CUMBERLAND
CITY COUNCIL

Ref: OA2021/0006

Subject: Request for comments-State Significant Development (SSD)
Application No: OA2021/0006
Property: 14 & 16 Kiara Crescent YENNORA NSW 2161
Proposal: Ministerial Consent - Yennora Liquid Waste Treatment Plant (SSD-10407)

Council has reviewed the submitted information and the Response to Submissions (RtS), and requests that the following matters be addressed:

Figure 2.1. Swept paths for heavy vehicles accessing the site at 14- 16 Kiora Crescent, Yennora. NSW Surveys PTY LTD, 8/11/19.

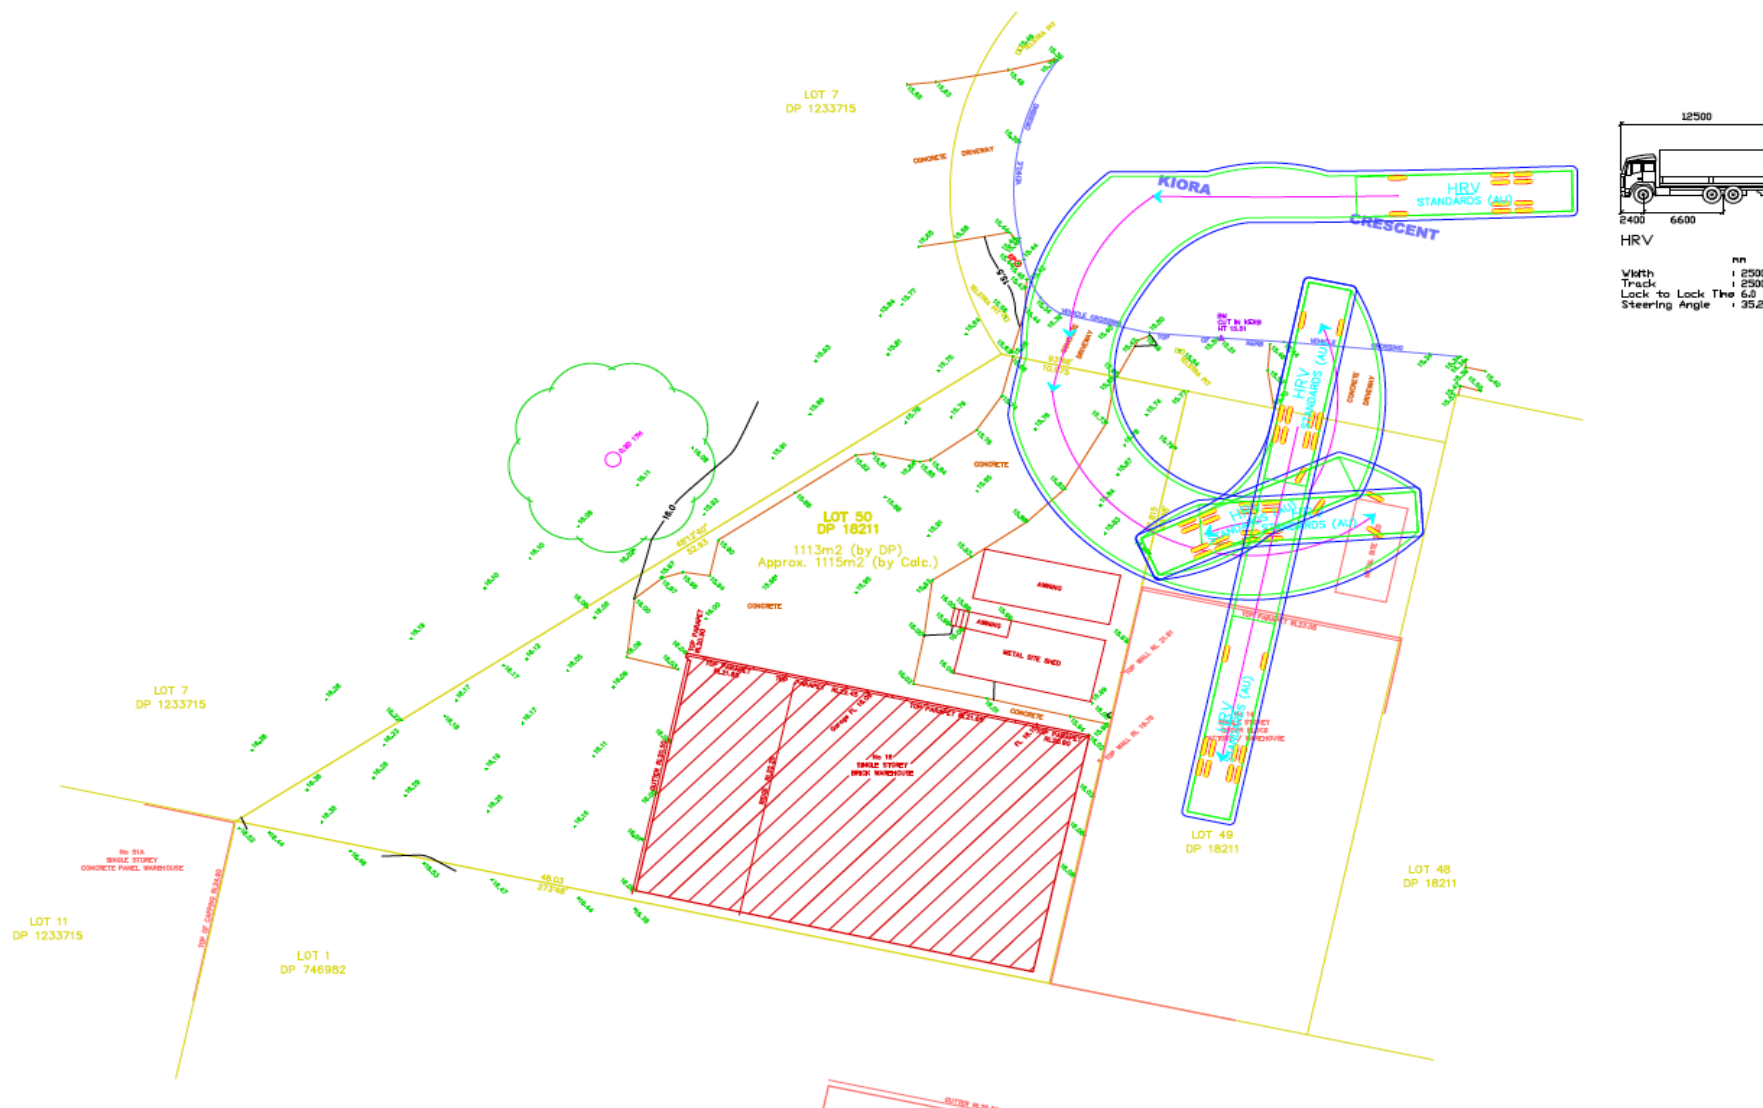
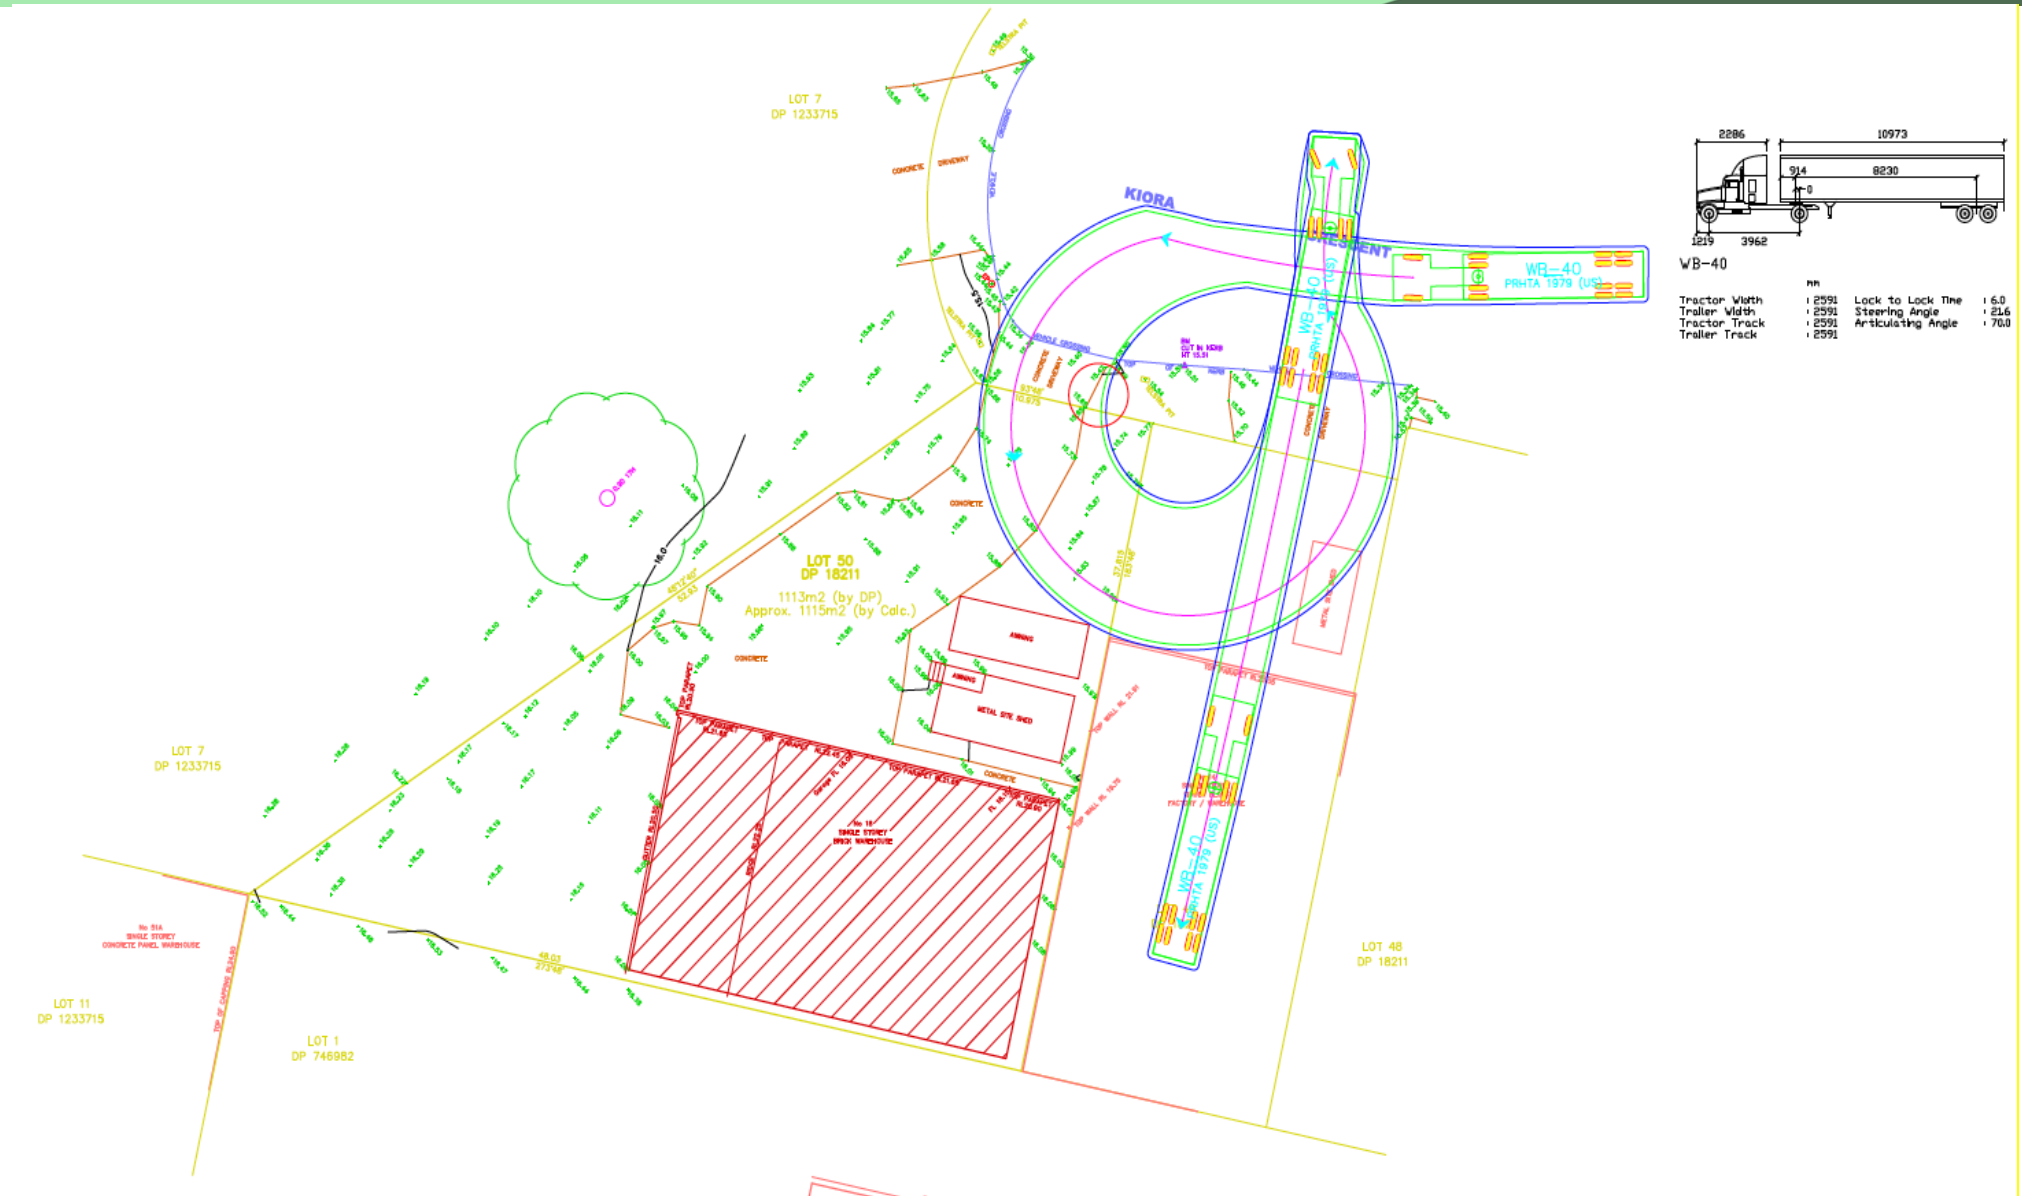
- d) Council will not support the proposed driveway widening. Driveways are provided for the site access only. All the turning manoeuvring shall be provided within the site. A separate approval shall be obtained from Council's Engineering section for any modification to the driveway. Swept path analysis submitted as part of the RTS clearly shows that the driveway widening is required for the reverse manoeuvring. Sketch from the RTS has been provided for reference:

- e) Reverse manoeuvring in Council's land is not permitted. It will compromise the safety. Vehicles should enter and leave the site in a forward direction. This condition has also been imposed as part of the schedule A of the development consent DA2013/351/1.

- j) All the vehicles shall enter and leave the site in a forward direction. This is also a requirement of the previous consent.
- ❖ Please note that following conditions have imposed as part of the development consent DA2013/351/1:
